From: Yolanda Padilla Moyer <ypadilla@bhinc.com>
Sent: Monday, December 23, 2019 5:04 PM
To: Cherne, Curtis; Roeder, James A.; Biazar, Shahab
Cc: Adeeb, Muhanned W; Kevin Patton (Kevin.Patton@PulteGroup.com)
Subject: RE: Del Webb 3A
Attachments: 30in SD 3.45%_stampedsigned.pdf; GRT_CAP_stampedsigned.pdf; 20180338_SD.PDF

From: Cherne, Curtis <CCherne@cabq.gov>
Sent: Wednesday, December 18, 2019 8:47 AM
To: Yolanda Padilla Moyer <ypadilla@bhinc.com>; Roeder, James A. <jroeder@cabq.gov>; Biazar, Shahab <sbiazar@cabq.gov>
Cc: Adeeb, Muhanned W <madeeb@cabq.gov>; Kevin Patton (Kevin.Patton@PulteGroup.com) <Kevin.Patton@pultegroup.com>
Subject: RE: Del Webb 3A

I have reviewed the Design Revision sheets 6R and 15 (should be 15R) as well as the drainage report stamp date 6-14-18 and the Amendment 1 labeled January 23, 2019, but stamped 1-23-18 (yes, 18, think off by one year) and provide the following comments:

CITY PROJECT NO.	ZONE MAP NO.	SHEET	OF
650482	H-8/9	5R	26

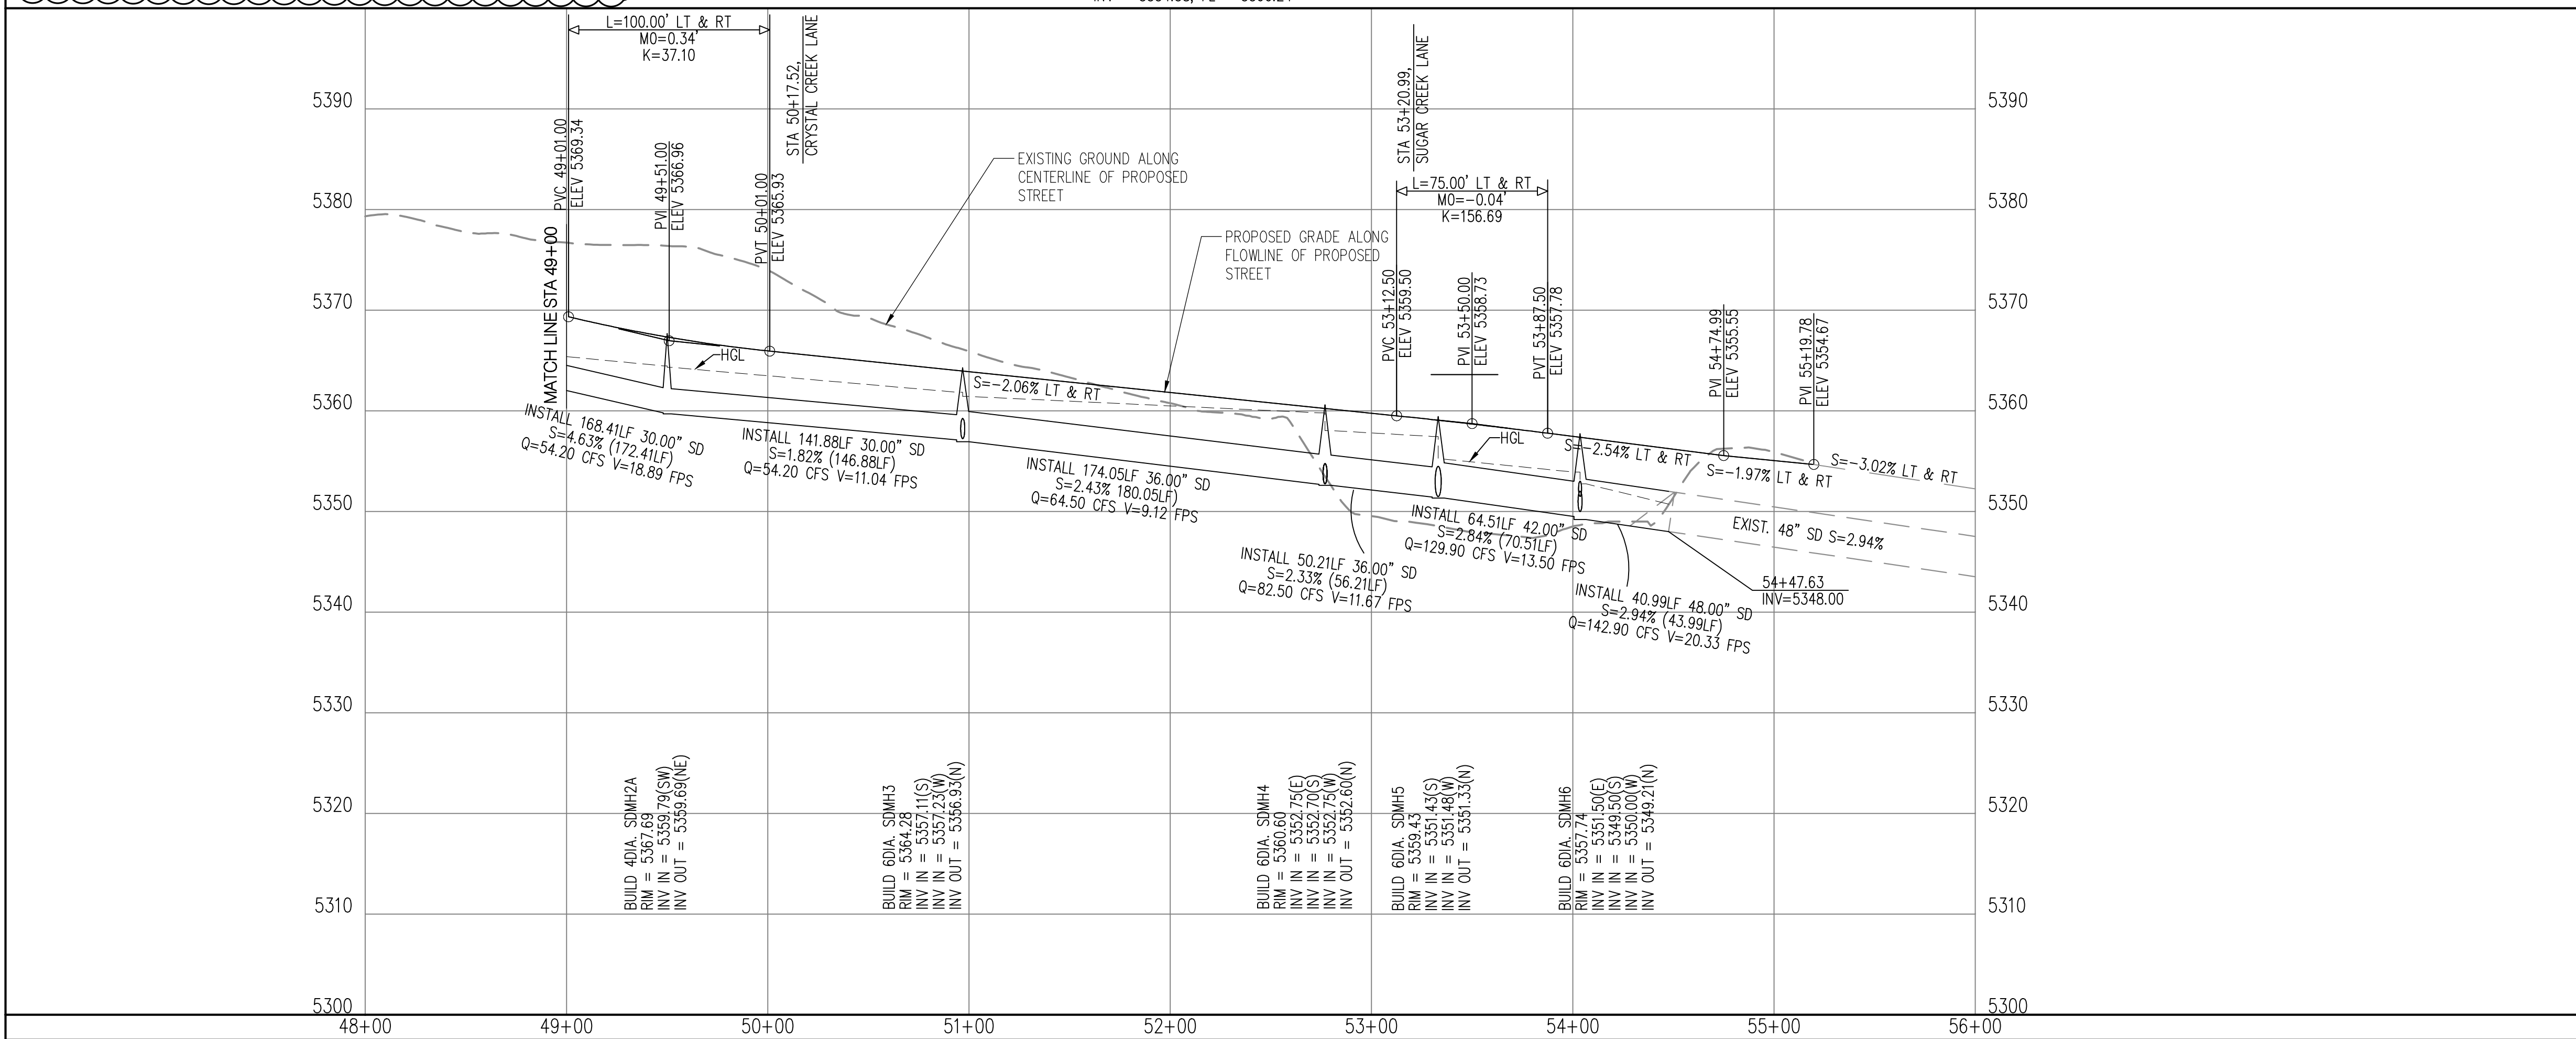
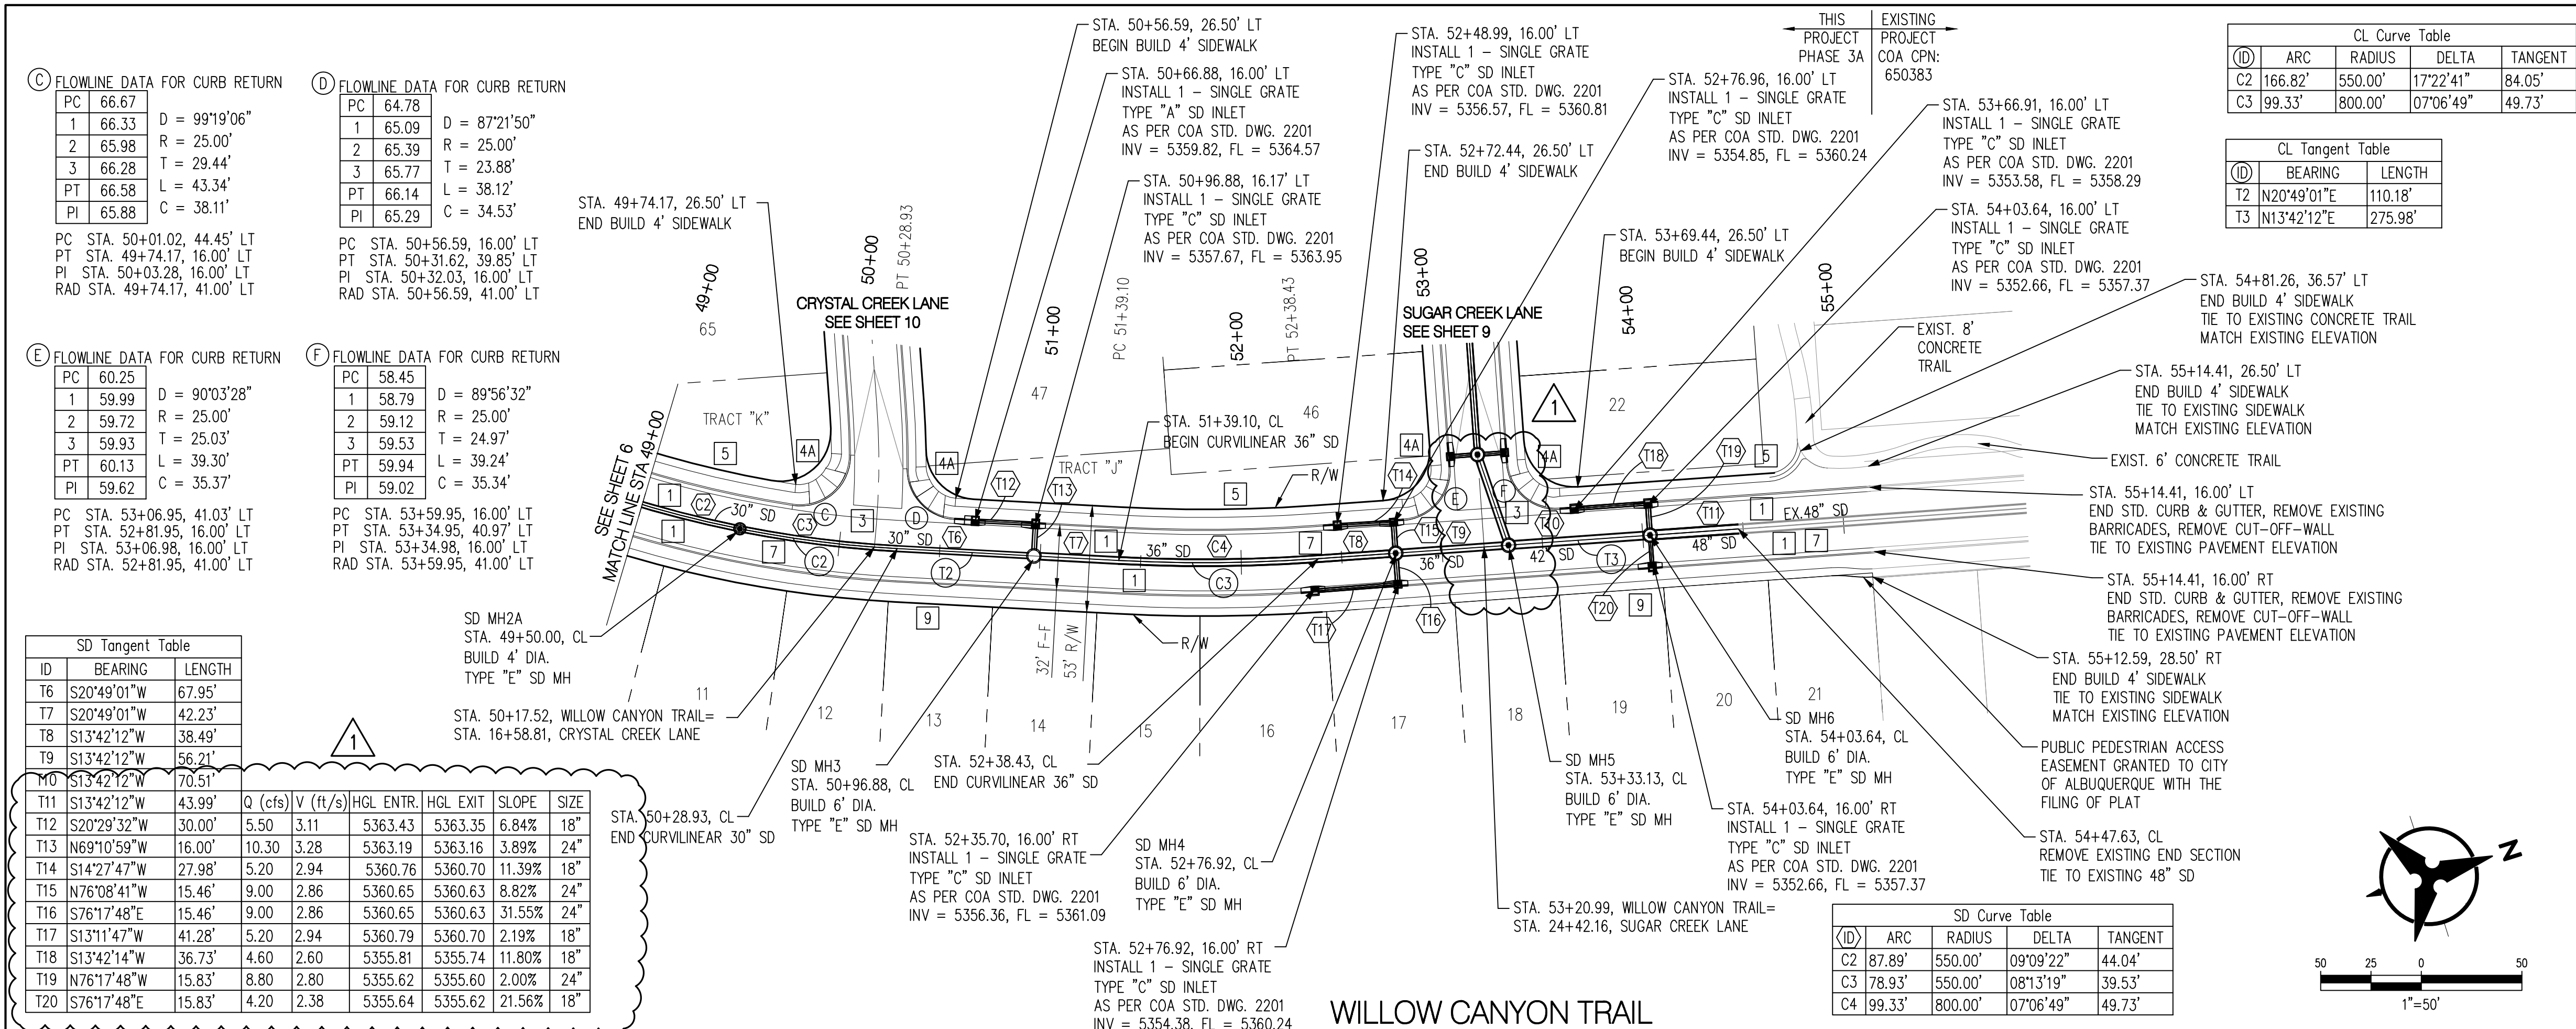
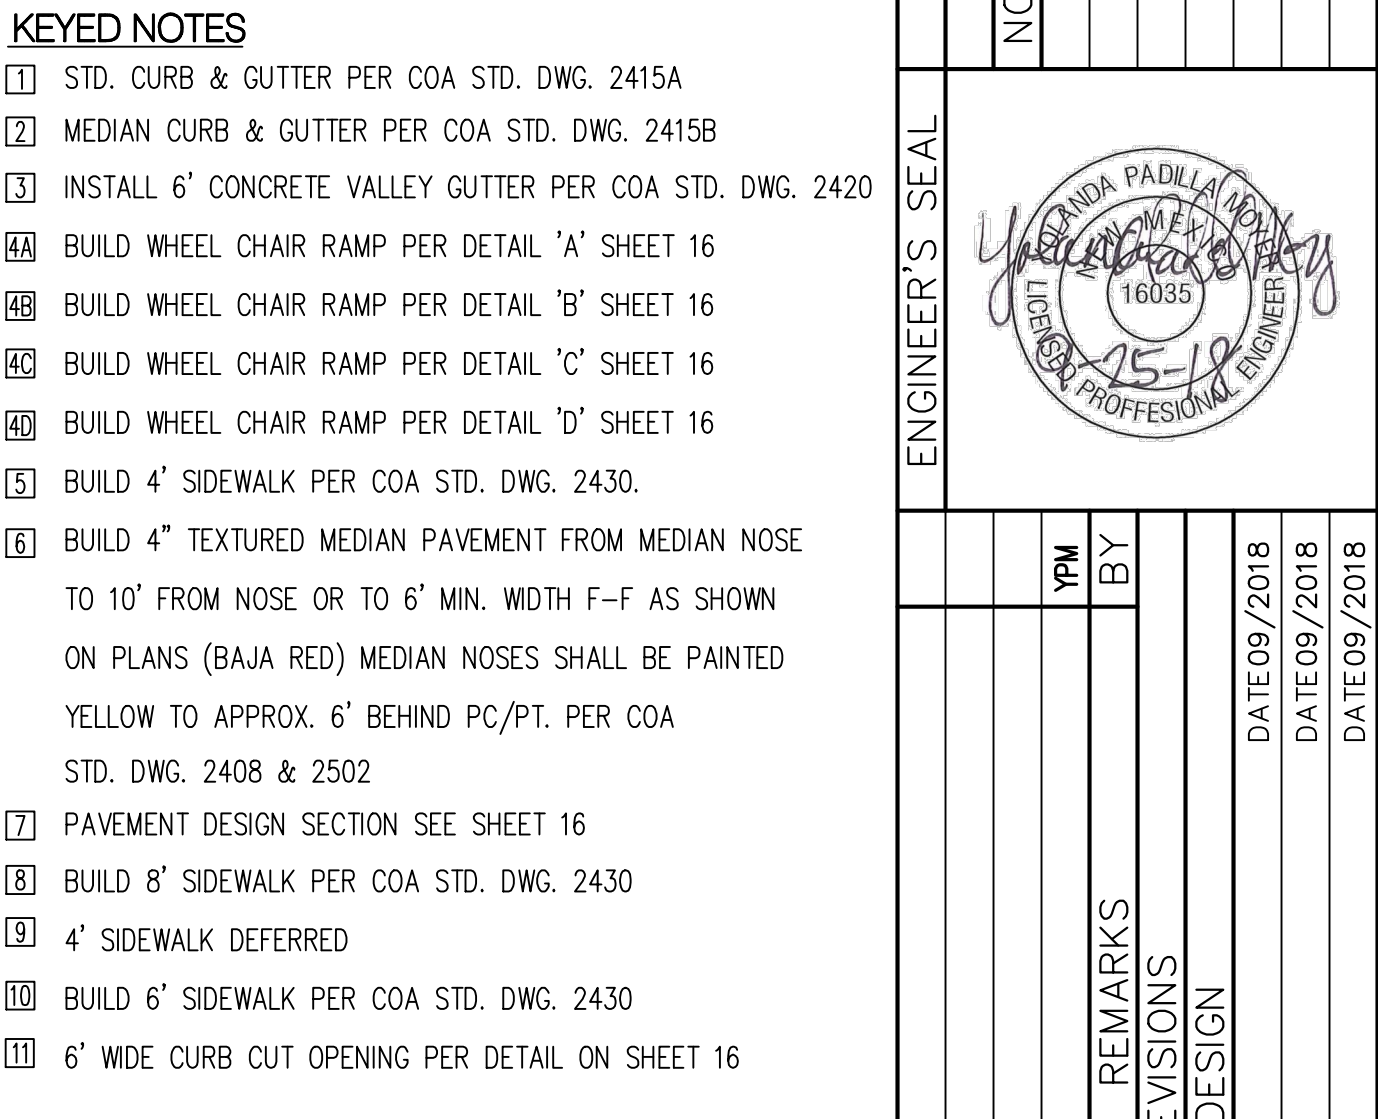
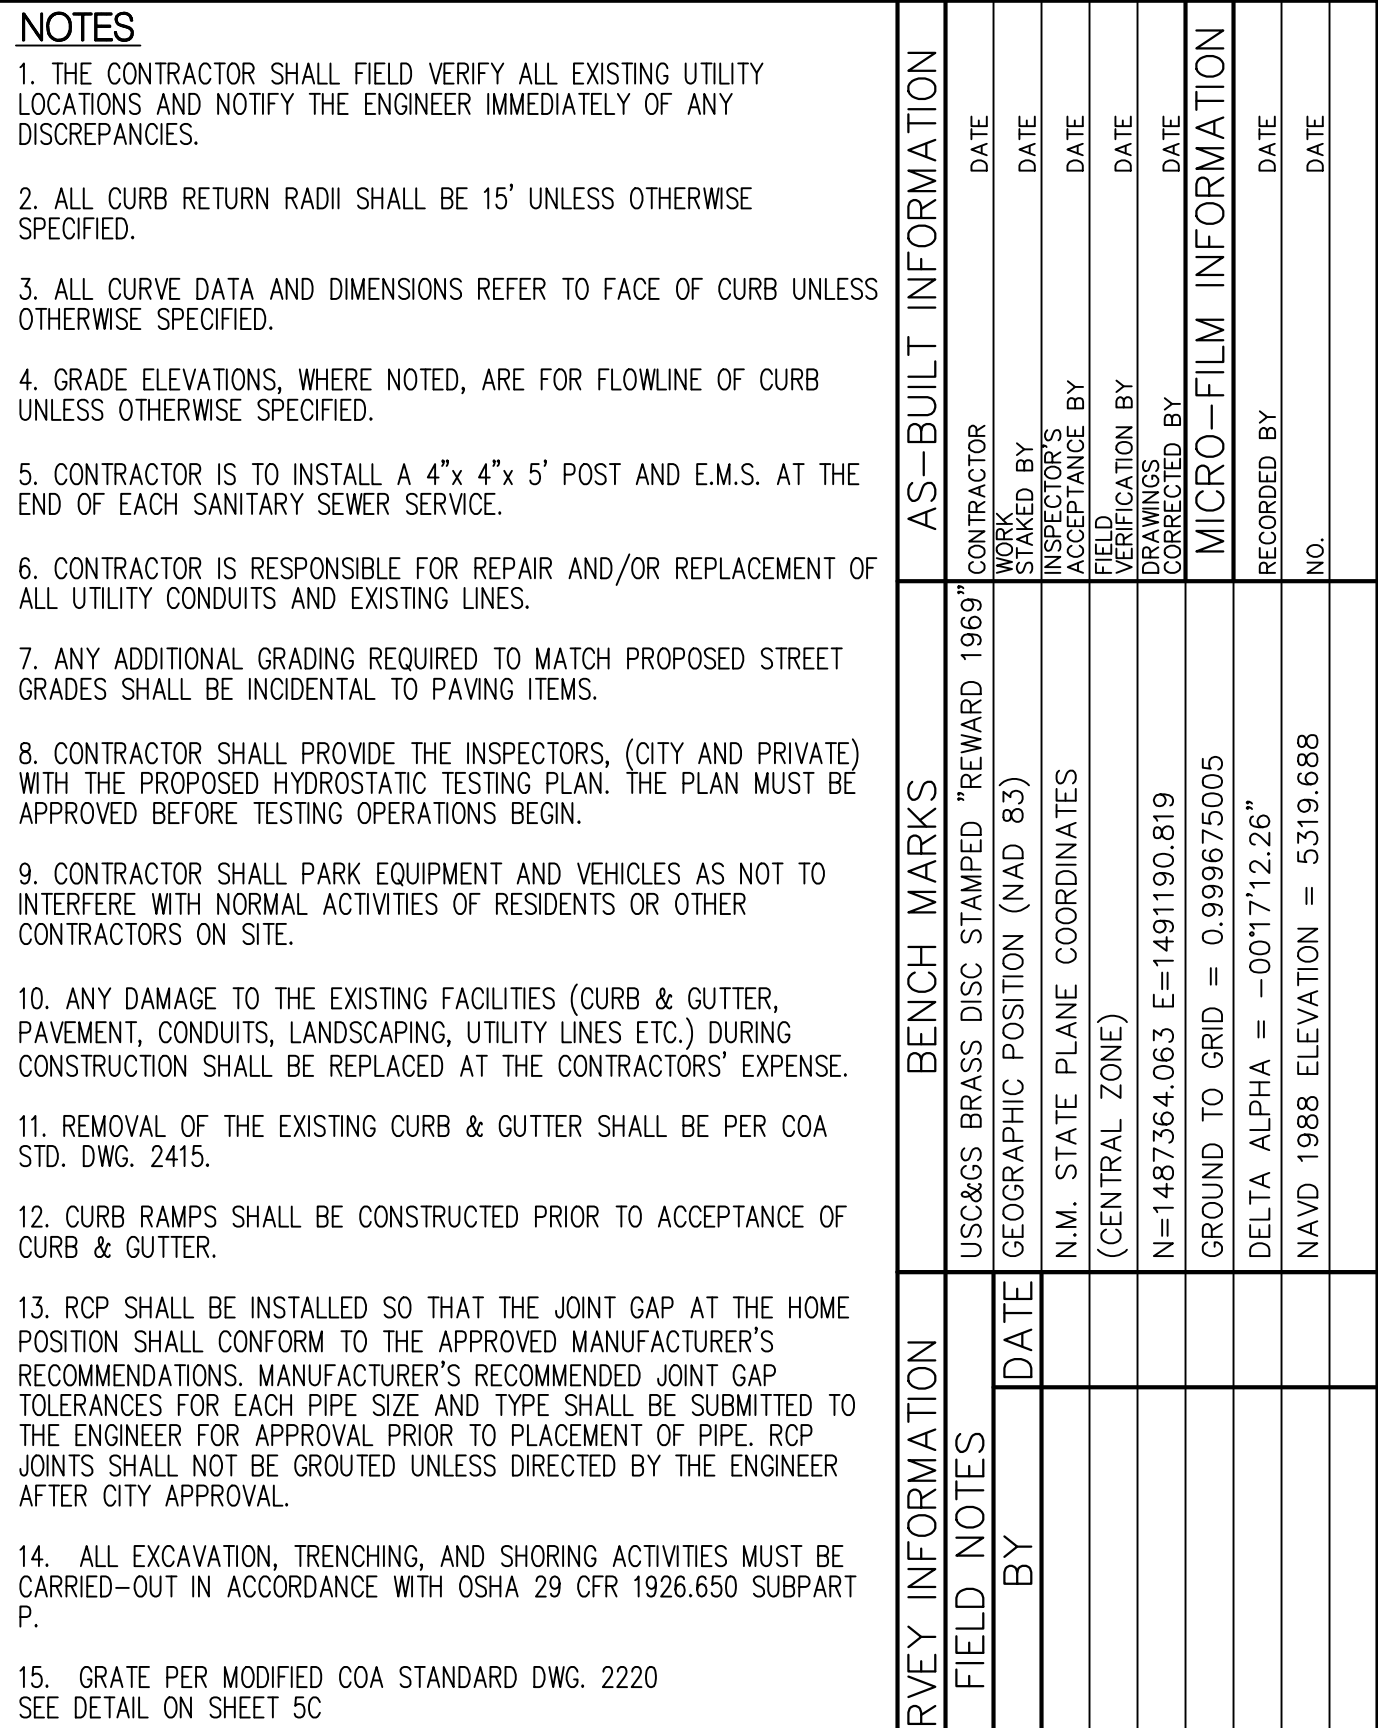
2. Comments on Sheet 6R:

- a. Show inlets and drain pipe on profile STA 43+90 or so. Pipe needs Q,V HGL. If not enough space on the plan, you could show this on Sheet 15R. Depending on Q and V, riprap pad may be inadequate. I did not see calcs for sizing riprap pad in the drainage report. **Q, V and HGL are provided on all SD pipes. The Q coming out of the sd is only 8.8cfs. The 10x10 pad is adequate.**
- b. For the inlets: delete FL elev and replace with TC elevation. **Inlet are built so I don't see the point in updating now.**
- c. Remove "Temporary Pond" near top of sheet. **Will crossout or relabel in the asbuilts**
- d. For the pipe draining the pond, change "1-24 flared section" to "1-30 flared section" as it is a 30" pipe. **Can be corrected in the asbuilt drawings.**
